The Sizewell C Project

Notification of Proposed Project Changes

PINS Reference Number: EN010012

October 2020

DRAWING NO:
SZC-SZ0100-XX-000-DRW-100205

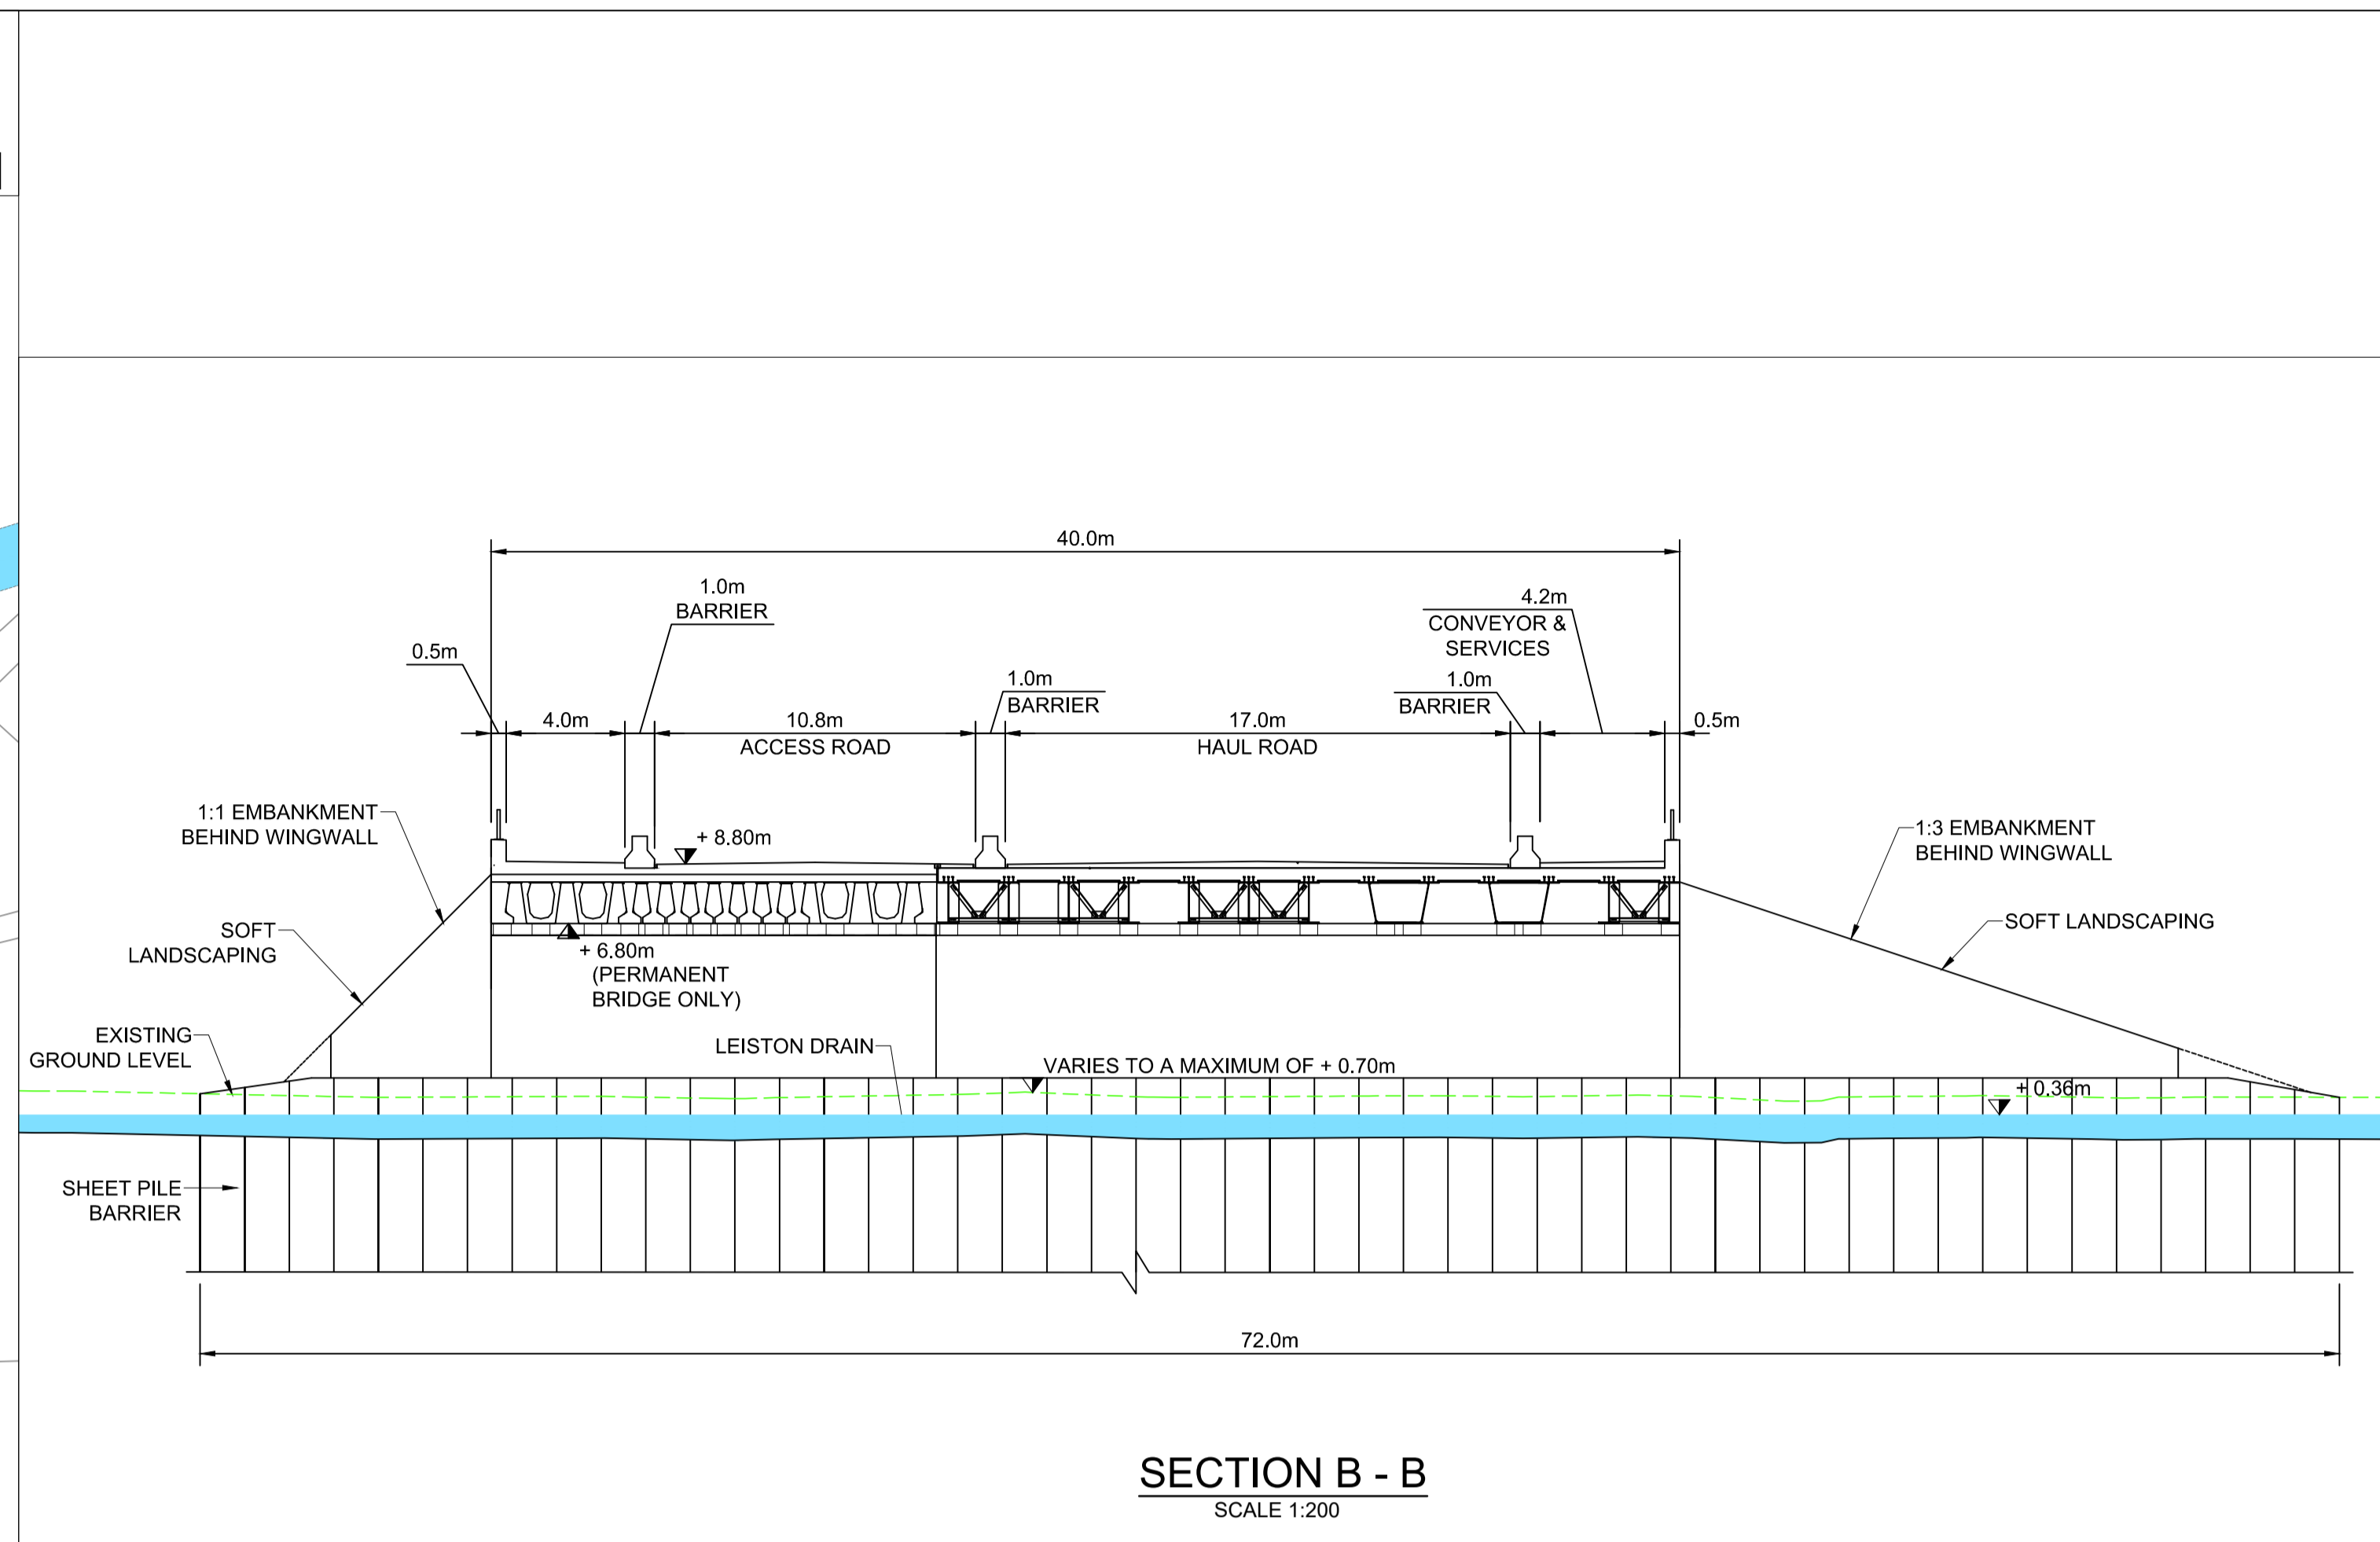
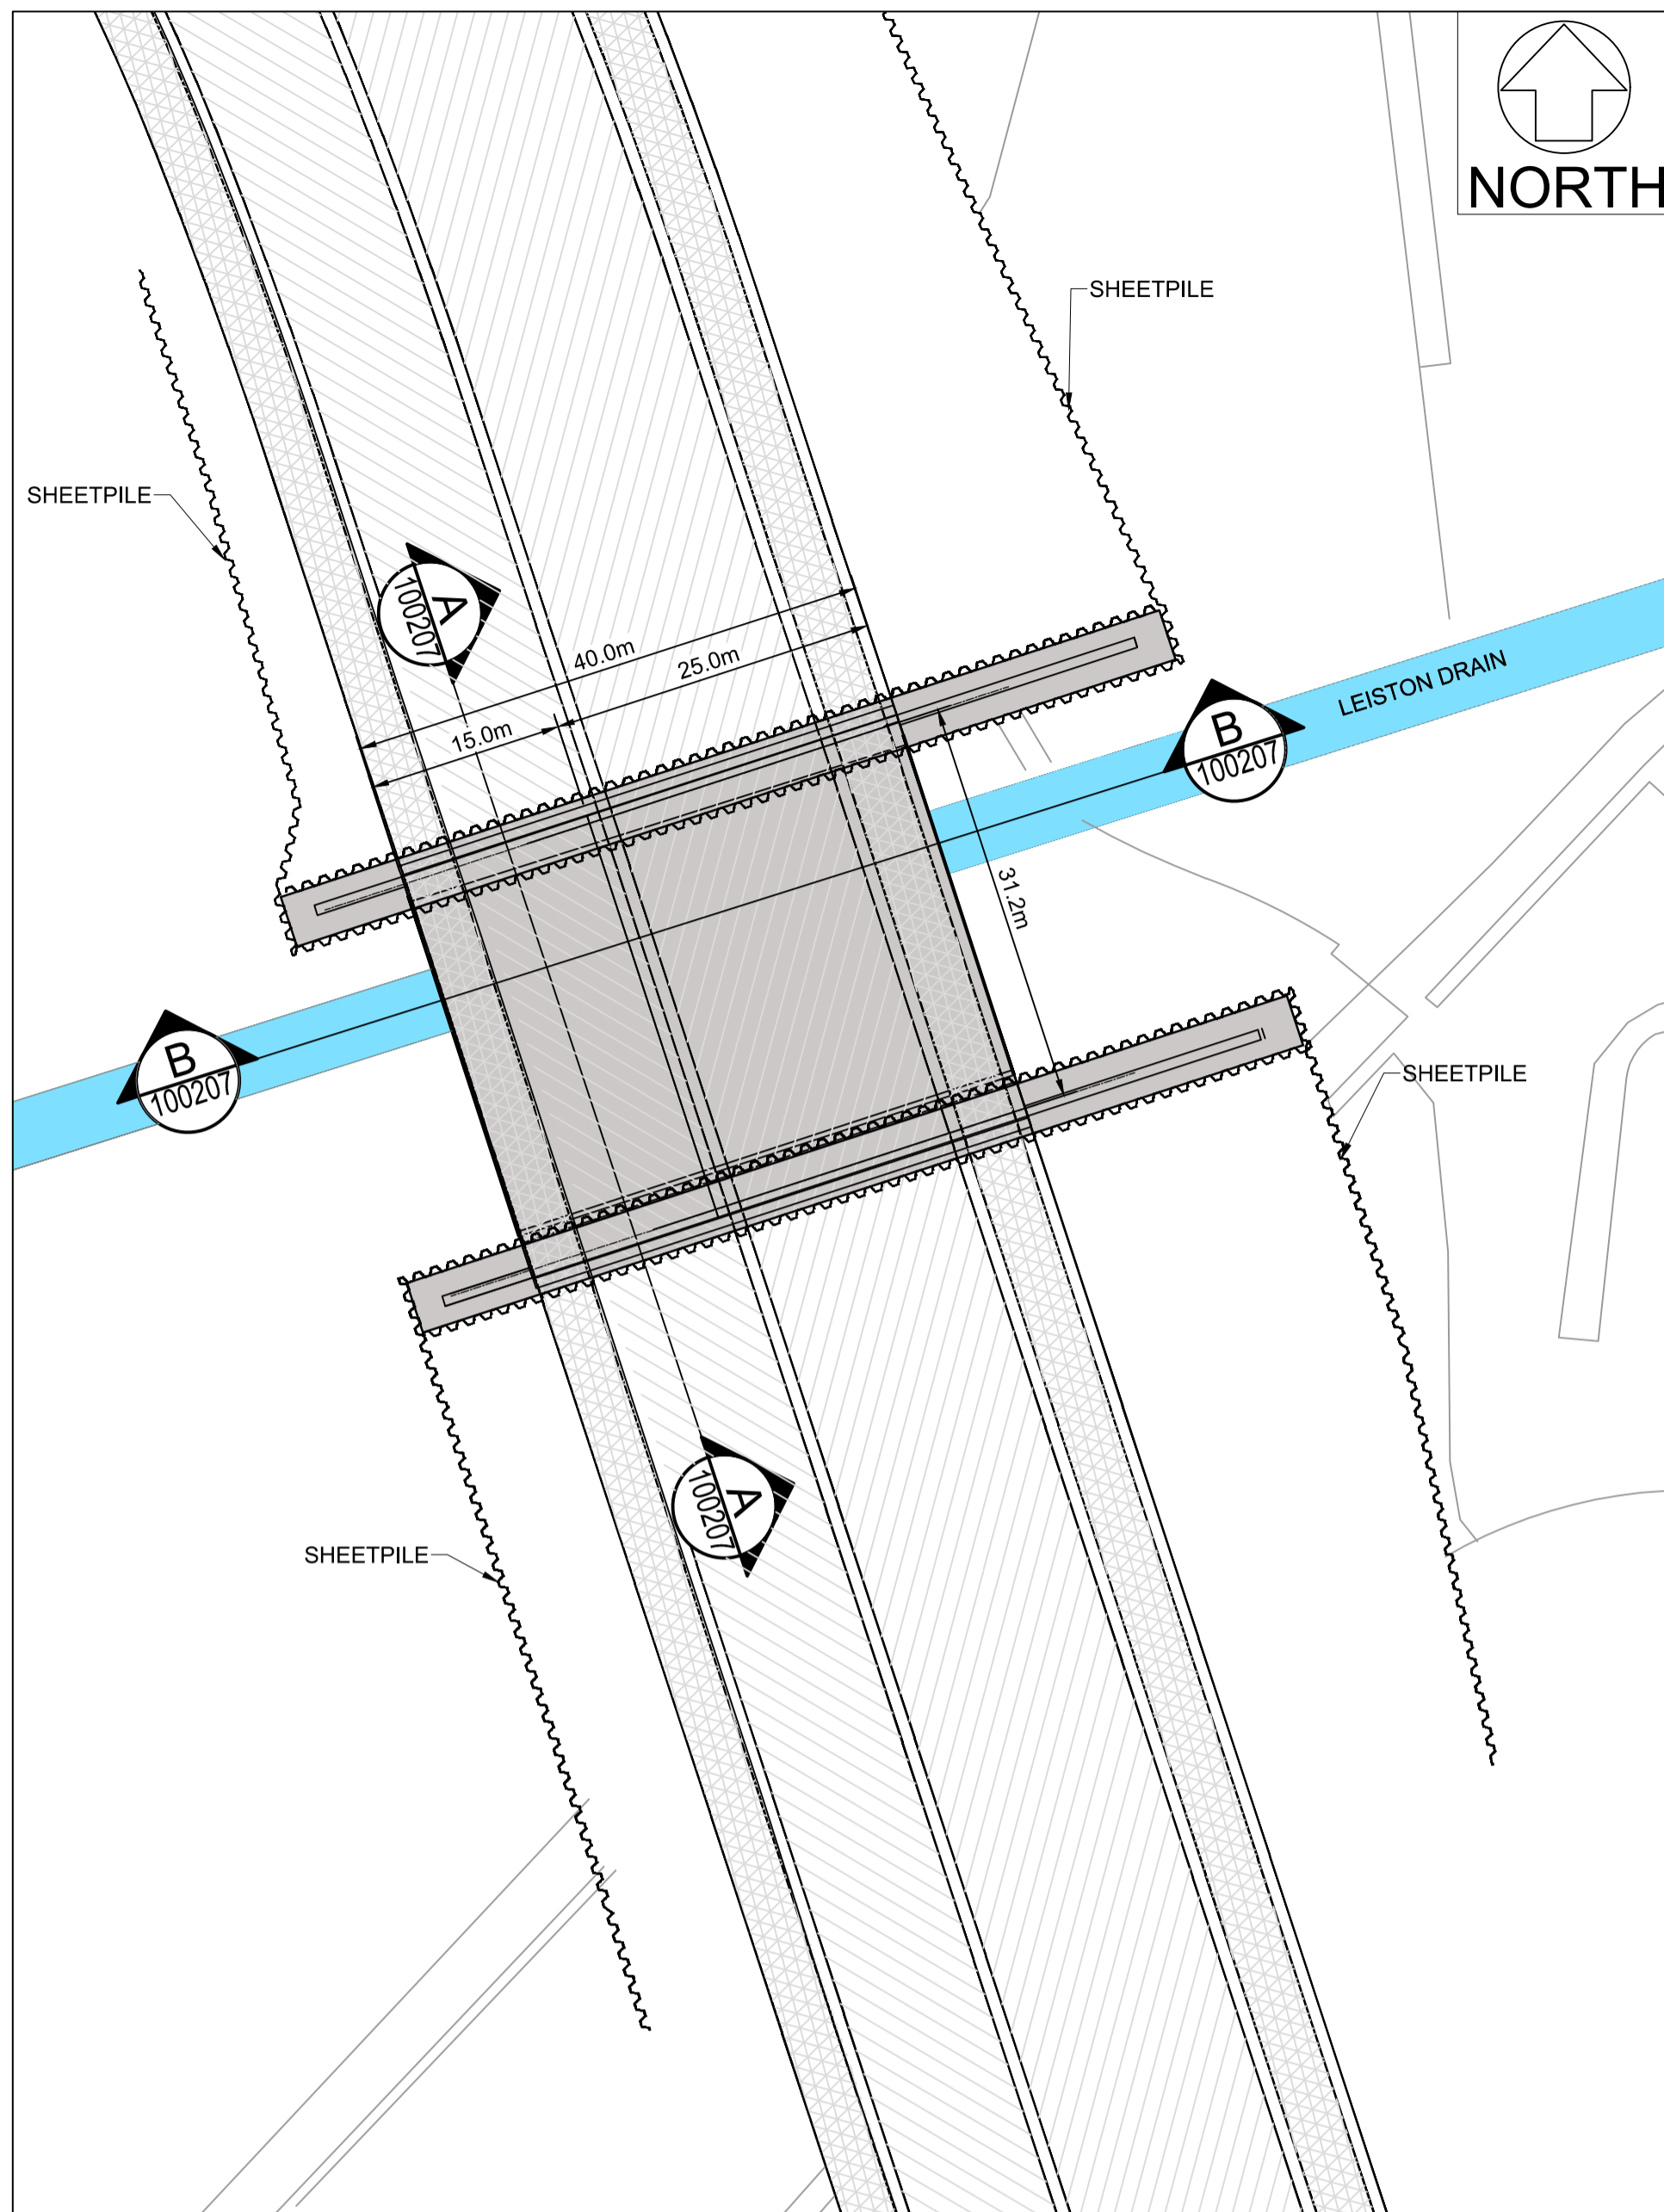
2.3.17 SZC Co. proposes to embed additional flood risk mitigation into the design of the SSSI Crossing by introducing additional flood relief culverts. This will enhance the mitigation already proposed at the crossing, namely the substantially oversized main culvert.
